60A Danforth St  
WPD Zone

## MEMORANDUM

**Subject:** Response to DeLuca-Hoffman Comments  
Merrill Industries – Rubb #7  
Site Location Application

NORTH SIDE ELEVATION

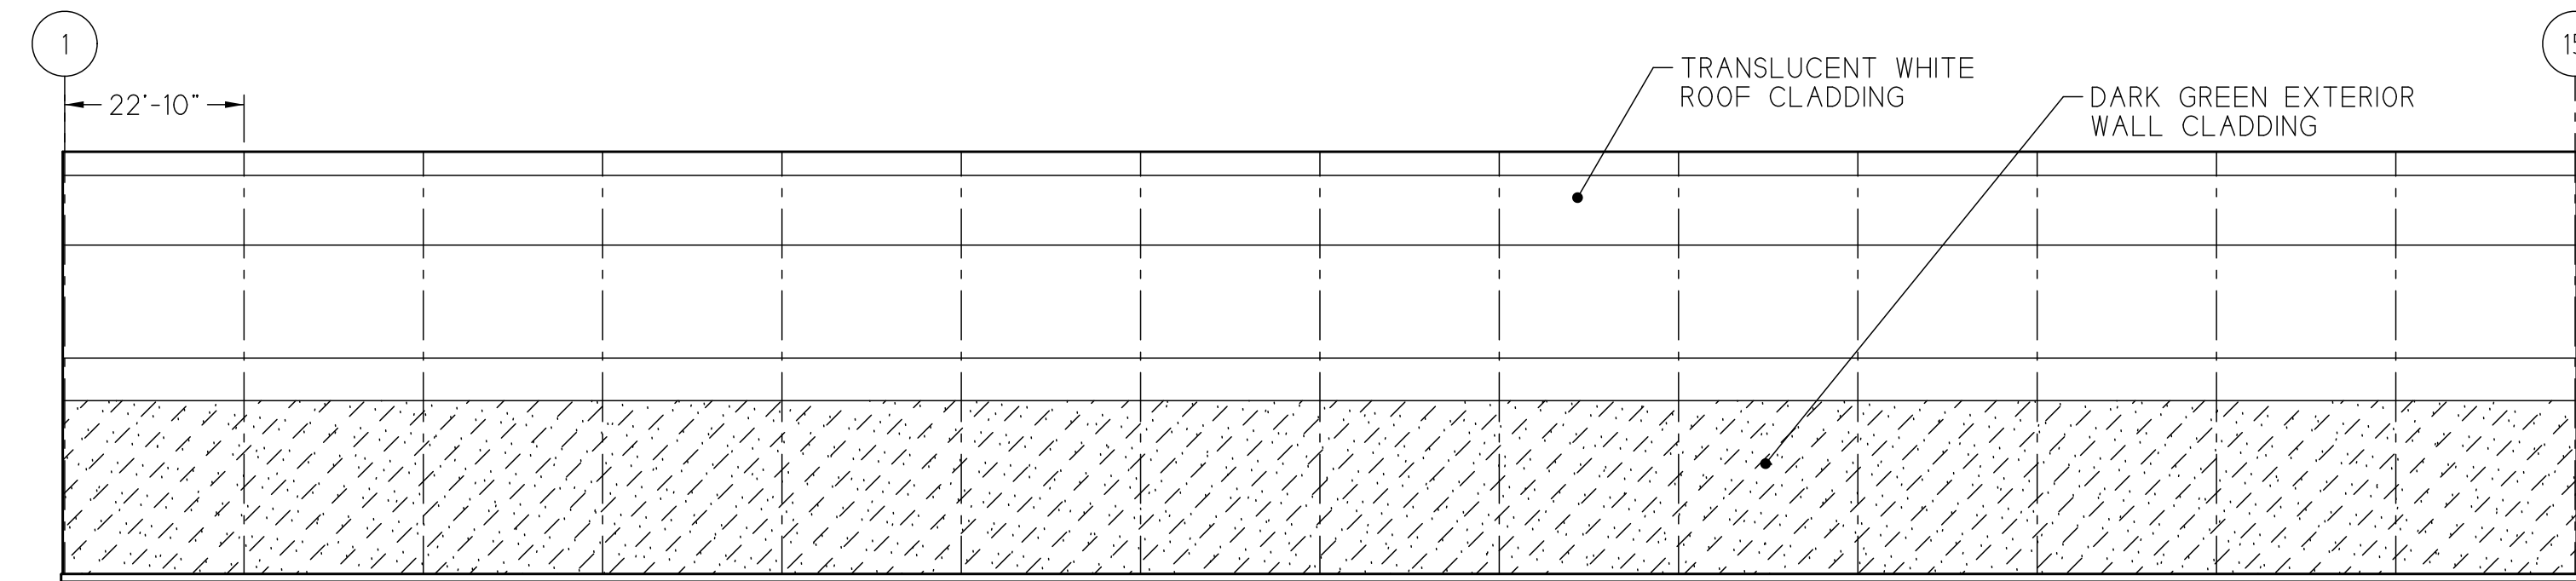
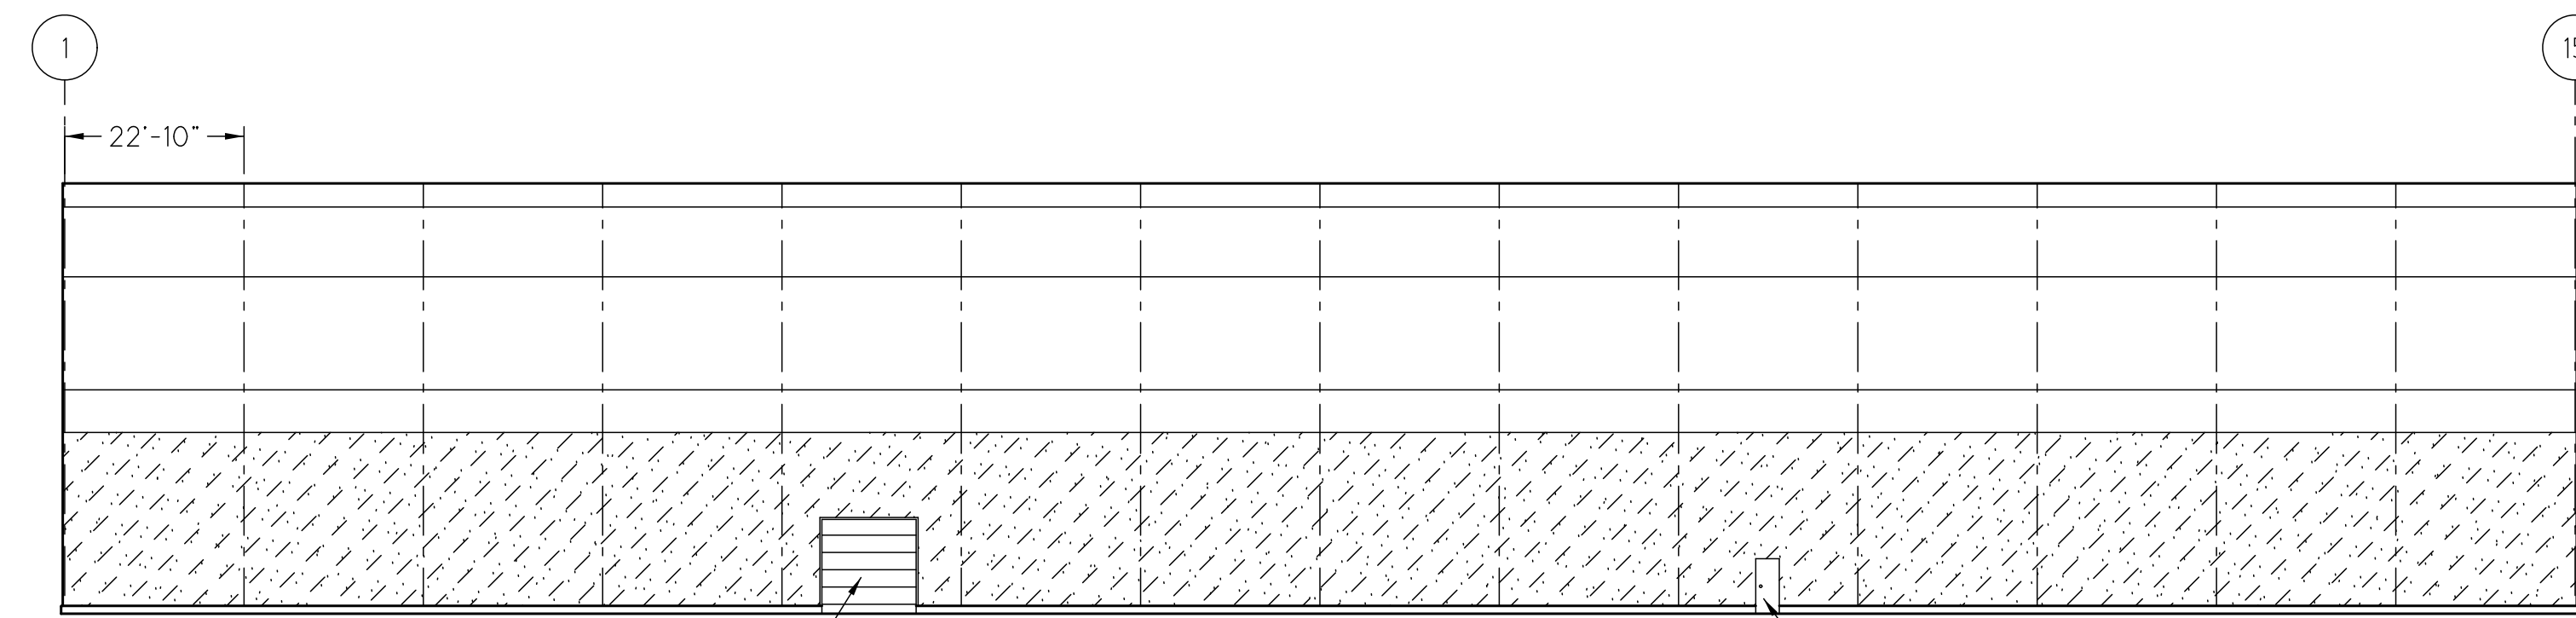
**Item 3h** – Lights will be located on all sides of the building. These are now shown on the attached drawings from Rubb and these are generally located 11' from grade.

PLAN VIEW

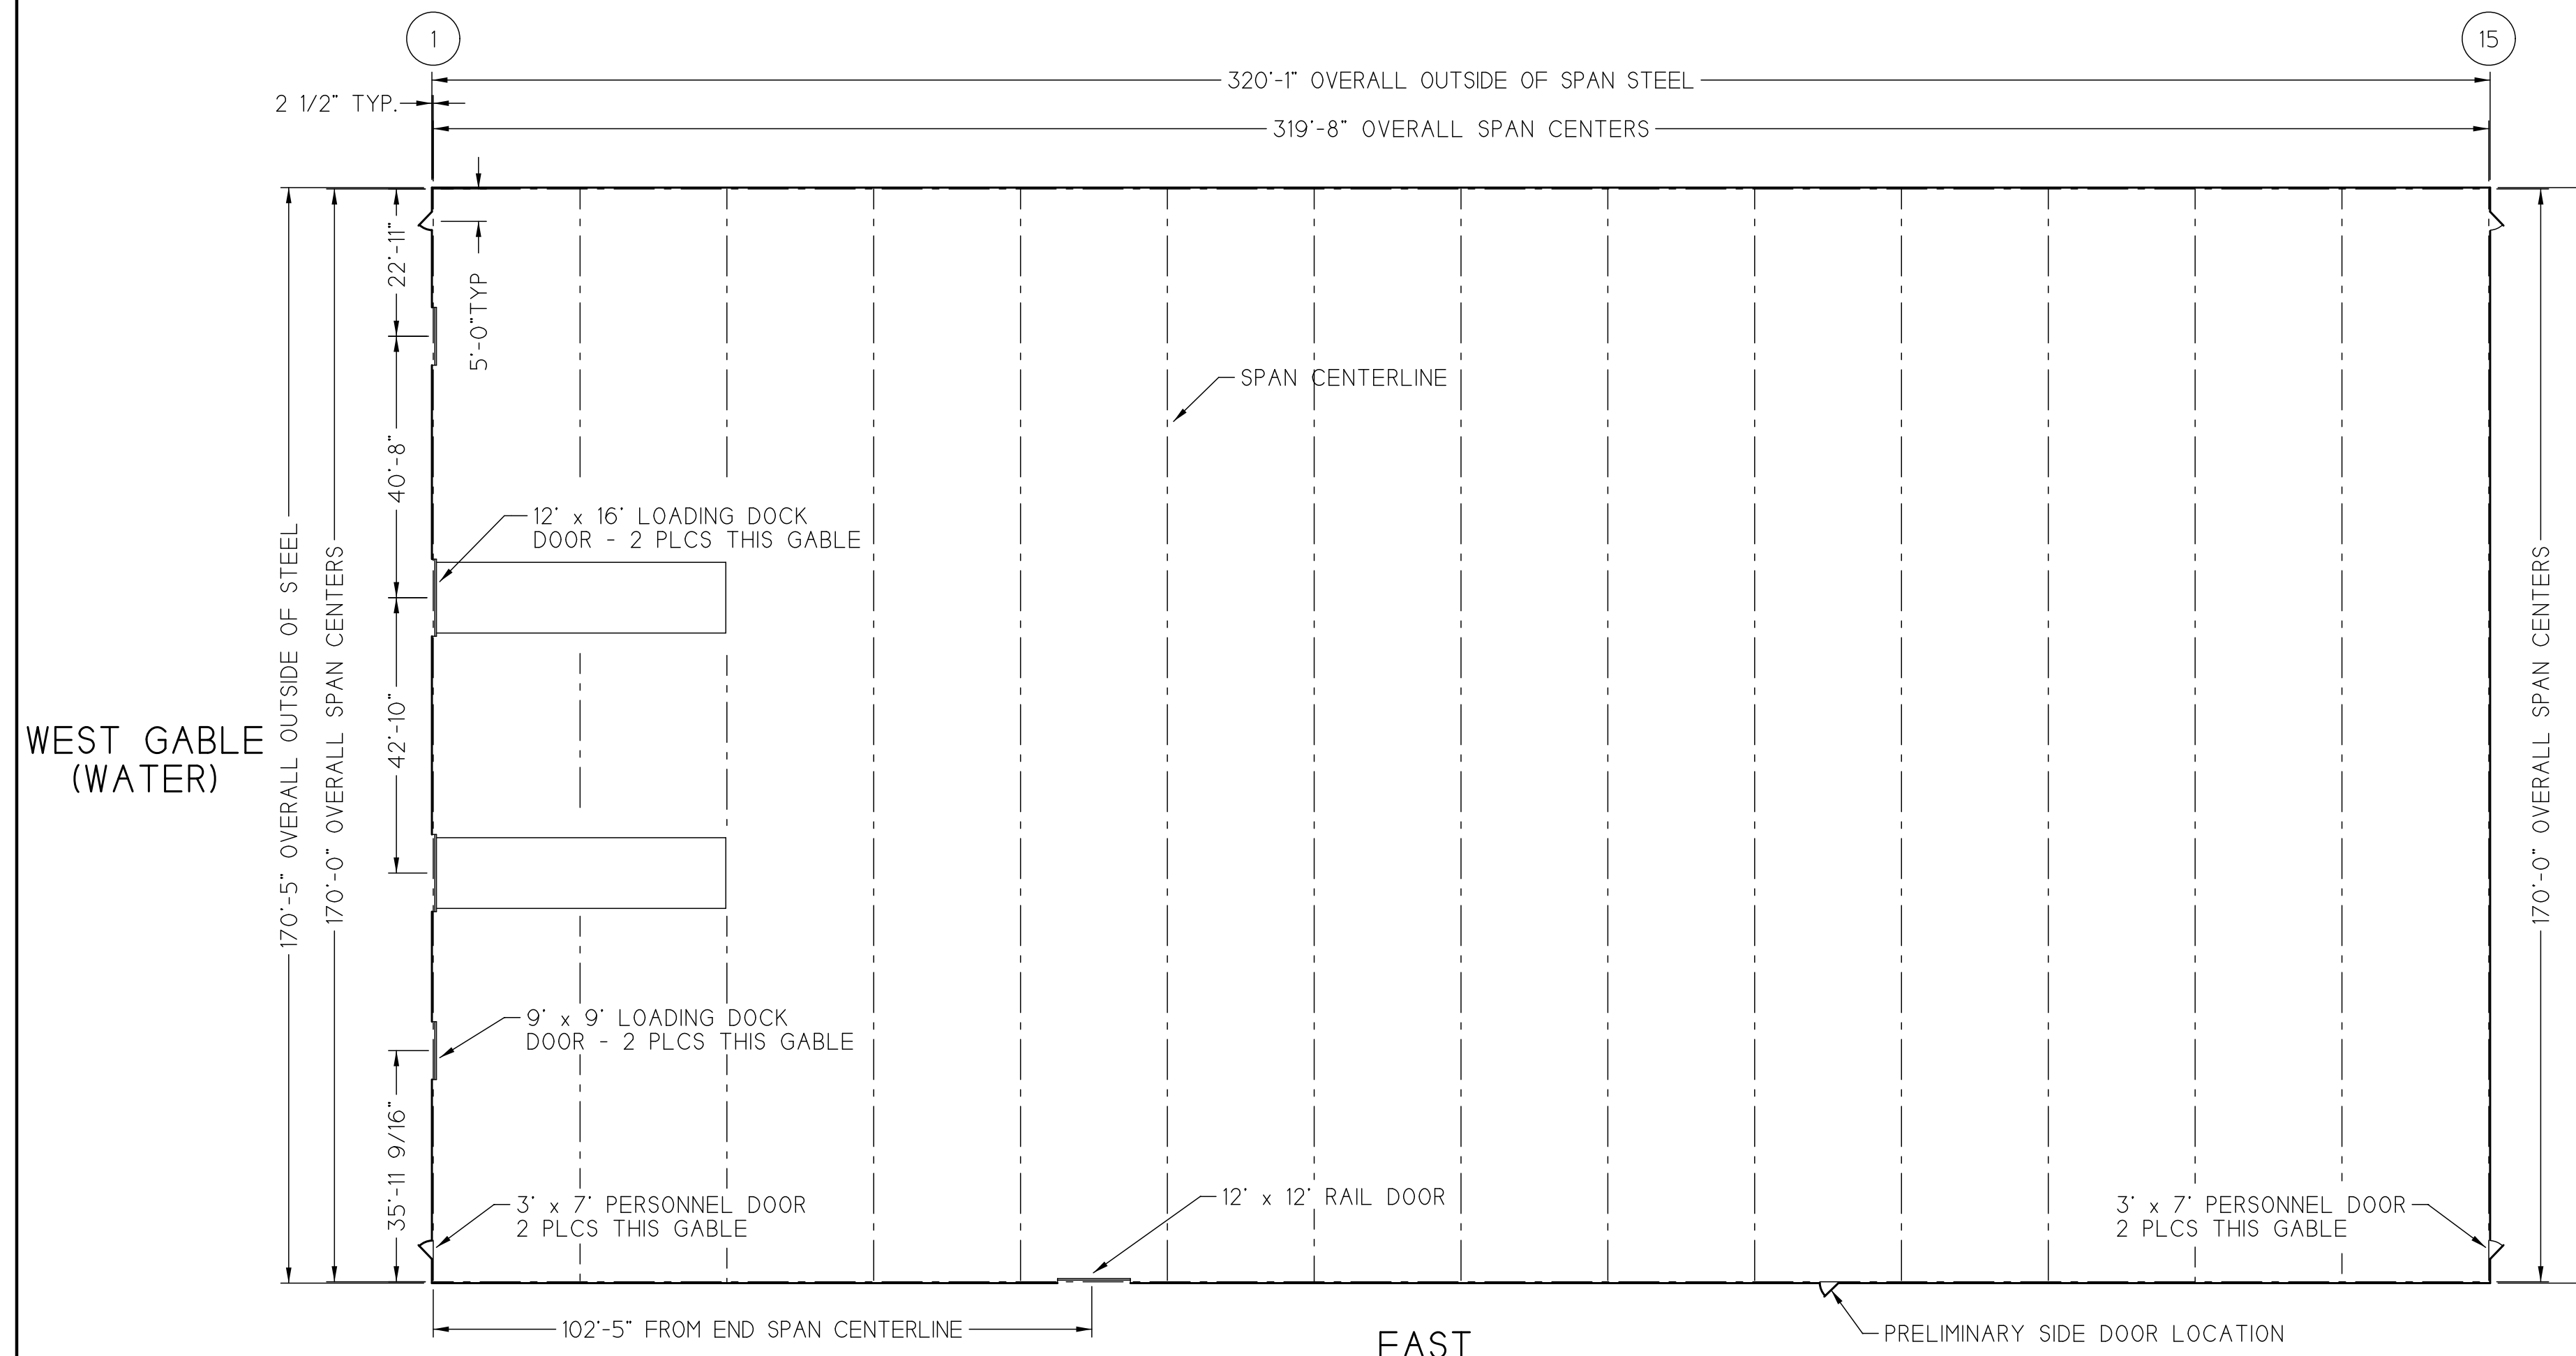
**Item 3g** – The building floor plan showing points of egress has been included with this submittal. Generally, it is seen that personnel doors are located at each corner of the building and one additional personnel door is located midway along the south side of the building.

TITLE PROPOSED RUBB VII - COMPARISON OF 170' SPAN BVE w/21' LEG TO RUBB VI - 140' SPAN BVE w/25' LEG				We Cover The World 	
GA	SP	SCALE	DRAWN	DATE	DRAWING NO.
7425 SF	230 LF	1" = 20'	DCN	2/4/05	81982

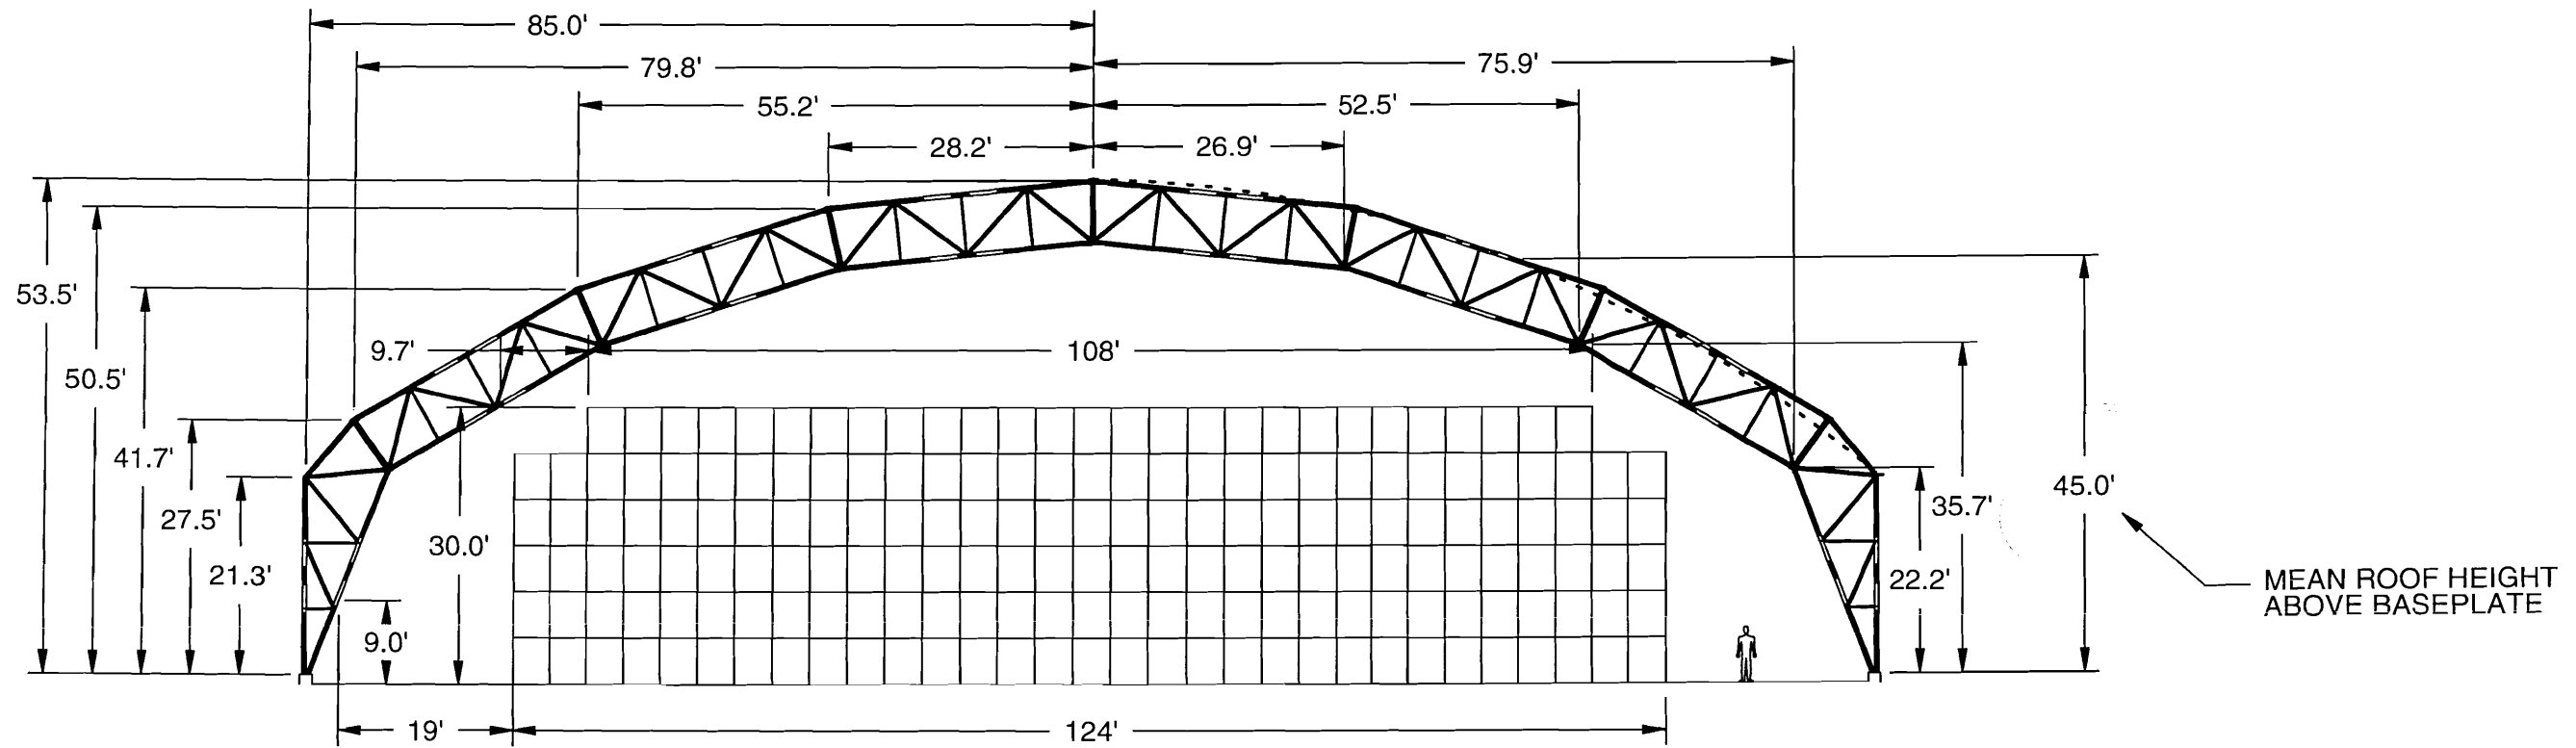
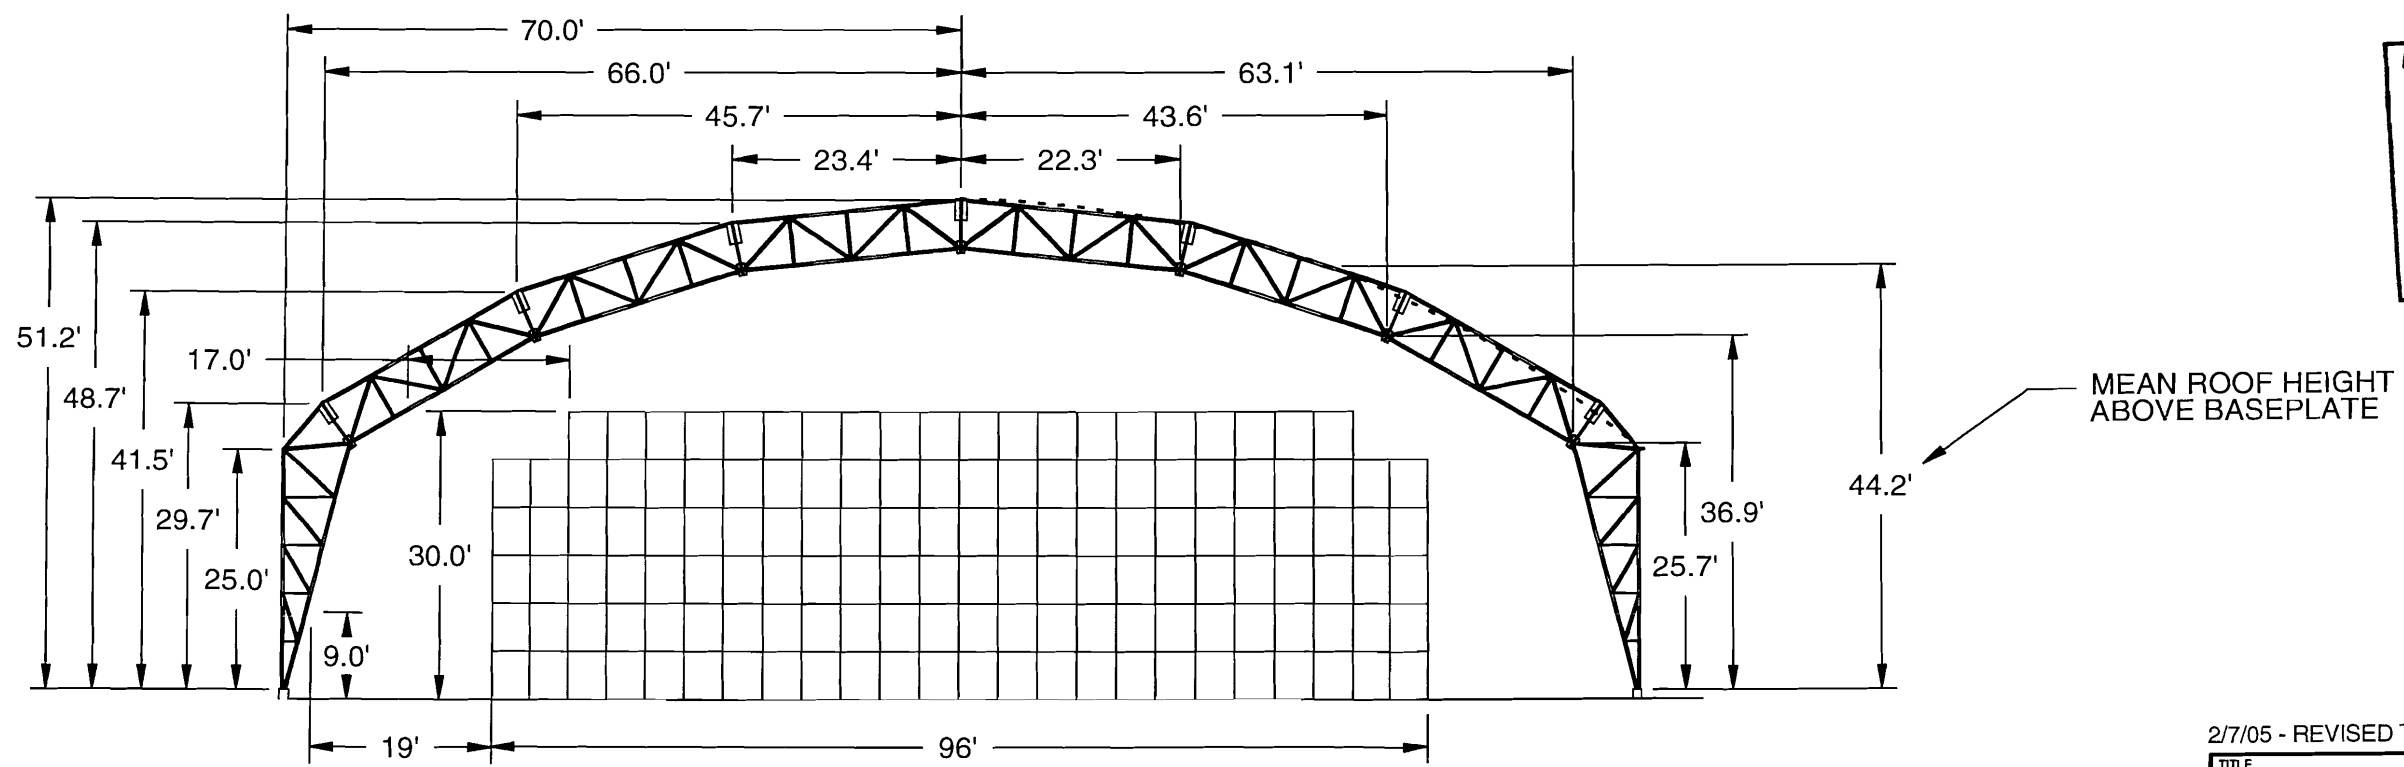
**Items 3d** – We have received sections of the building from Rubb Building Systems which show the height of the building.
